From: Diane Clarke <Diane.CLARKE@networkrail.co.uk>
Sent: 26 January 2023 12:41
To: Planning
Subject: ribble valley 3/2022/0966 Crow Trees Farm Crow Trees Brow Chatburn 39 residential units Network Rail comments
Attachments: Network Rail dev form Asset-Protection-Initial-Enquiry-Questionnaire.docx

Planning Application No: 3/2022/0966

Proposal: Proposed erection of 39 residential units with access, parking and landscaping.

Location: Crow Trees Farm Crow Trees Brow Chatburn BB7 4AA

CLIENT	Pringle Homes				
PROJECT	Proposed Residential Development at Crow Trees Farm, Crow Trees Brow, Chatburn, Clitheroe, Lancashire, BB7 4AA				
DRAWING	Proposed Boundary Treatment Details				
DRAWN	JAL	DATE	04/11/22	NUMBER	21/139/P04
SCALE	Varies	SHEET	A1	REVISION	B

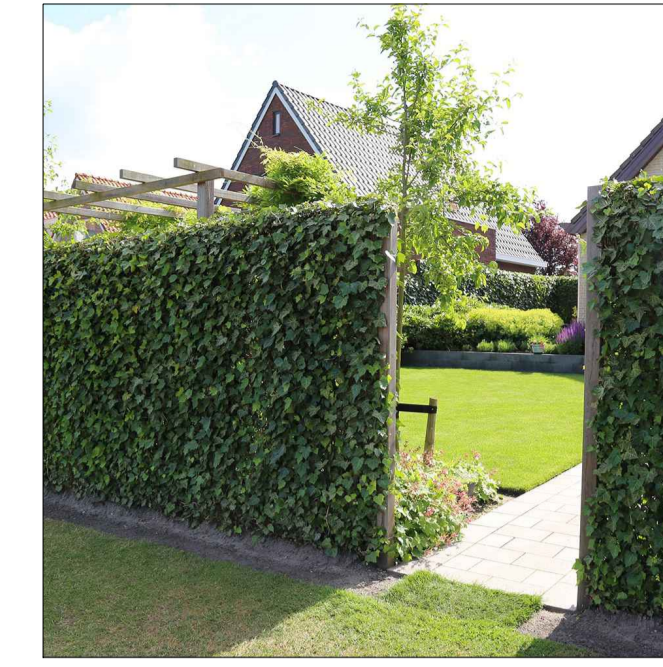
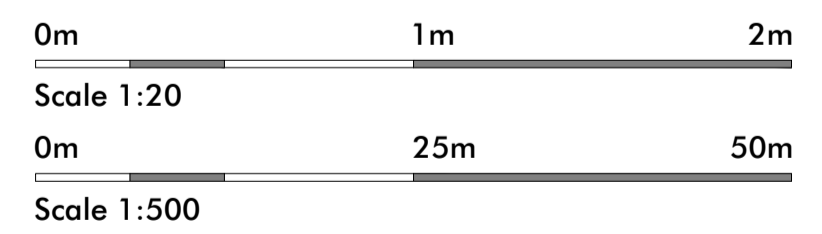
Fencing

- A suitable trespass proof steel palisade fence of a minimum height of 1.8m adjacent to the boundary with the railway/railway land.
- The fence must be wholly constructed and maintained within the applicant's land ownership footprint.
- All foundations must be wholly constructed and maintained within the applicant's land ownership footprint without over-sailing or encroaching onto Network Rail's boundary.

- The fence is **REQUIRED** be set back at least 1m from the railway boundary to ensure that Network Rail can maintain and renew its boundary treatments.
- Existing Network Rail fencing, and boundary treatments, must not be damaged or removed in any way.
- Network Rail will not allow any maintenance works for proposal fencing or proposal boundary treatments to take place on its land.
- Proposal fencing must not be placed on the boundary with the railway.
- Any fencing over 1.8m in height will require agreement from Network Rail with details of foundations and wind loading calculations submitted for review.
- The fence should be maintained by the developer and that no responsibility is passed to Network Rail.

“Prior to occupation of the site the developer is to provide a suitable trespass proof fence adjacent to the boundary with the railway; the fencing details to be submitted to the council and Network Rail for agreement.”
